Application by Millbrook Power Limited for an Order Granting Development Consent for a Proposed Millbrook Power project

The Examining Authority's Written Questions and Requests for Information (ExA WQs)

Issued on Tuesday 20 March 2018

September 2017	Drawing Number	Revision
A3 Scale	NTS	A
Drawn by	KIM	FIGURE 12.2 31116/3010/002
Checked by	JPH

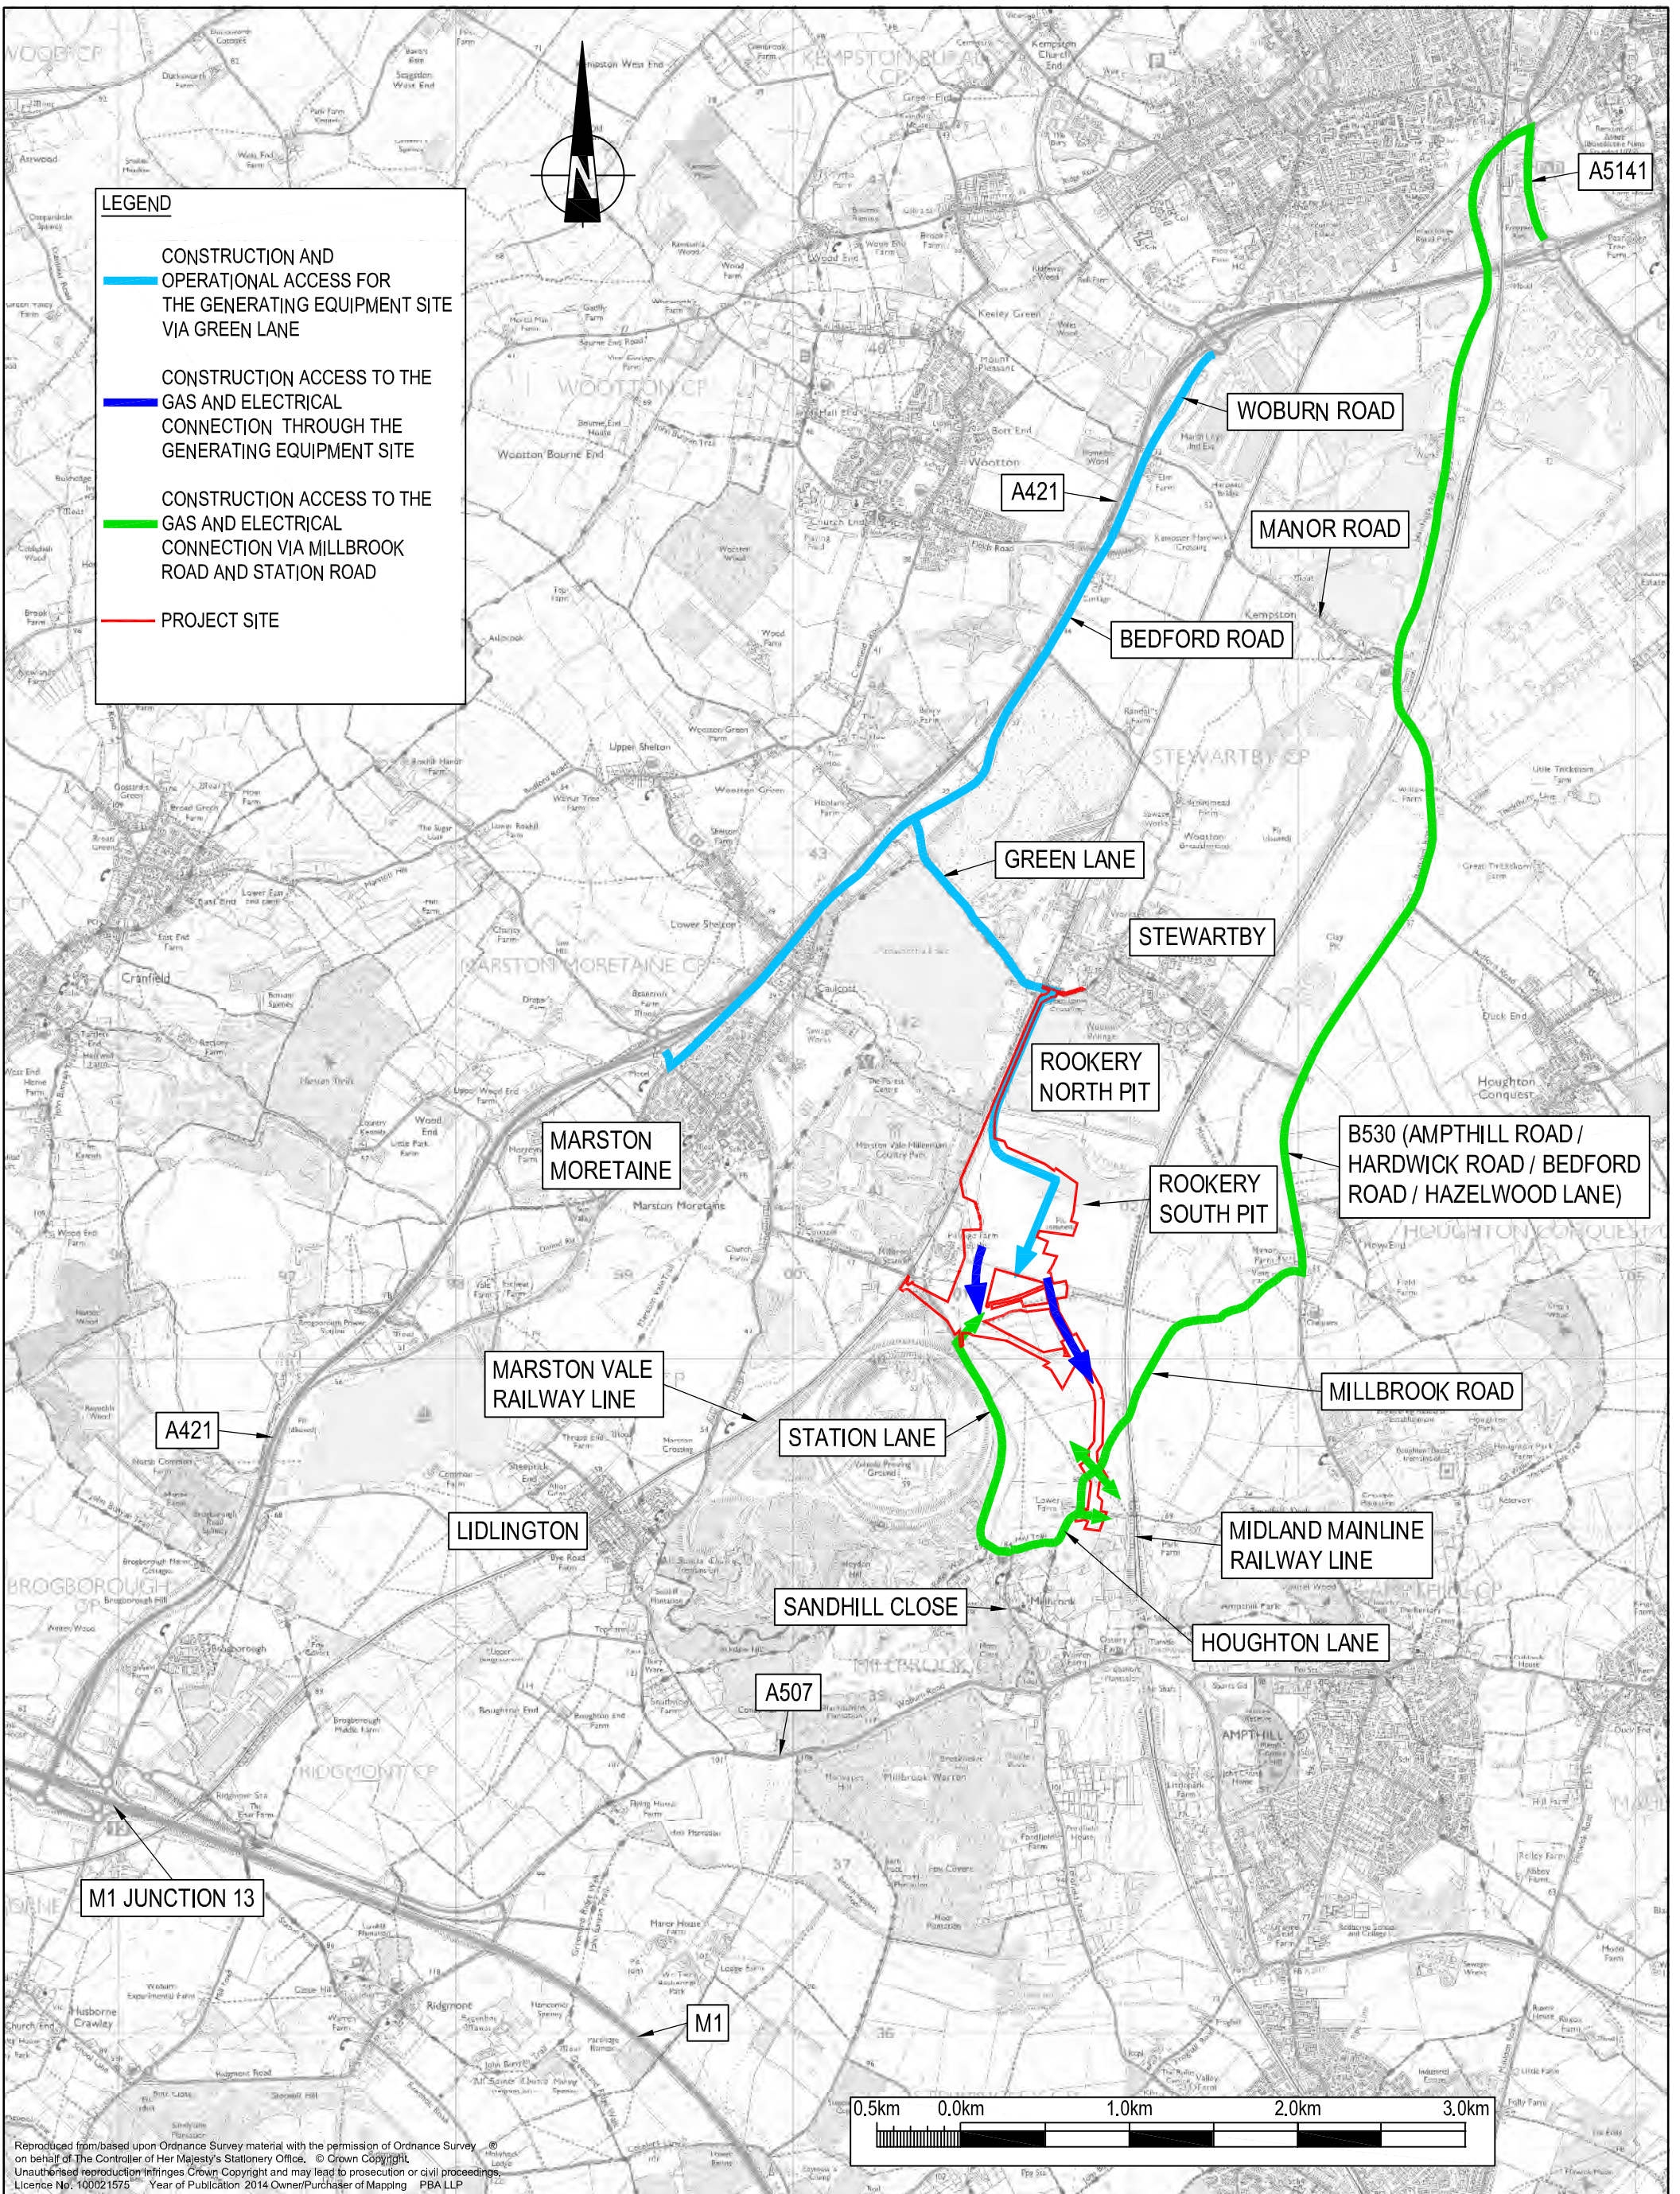
1.0.8	Applicant		ES paragraph 3.1.13 refers to road access to the site being shown on Figure 1.2 and paragraph 3.2.15 refers to a temporary construction laydown area. Figure 1.2 does not show either of these elements. Please confirm whether the access routes listed here are those shown in Figure 12.2 and the laydown areas are as shown in Figure 3.1 or provide further figures showing the details.
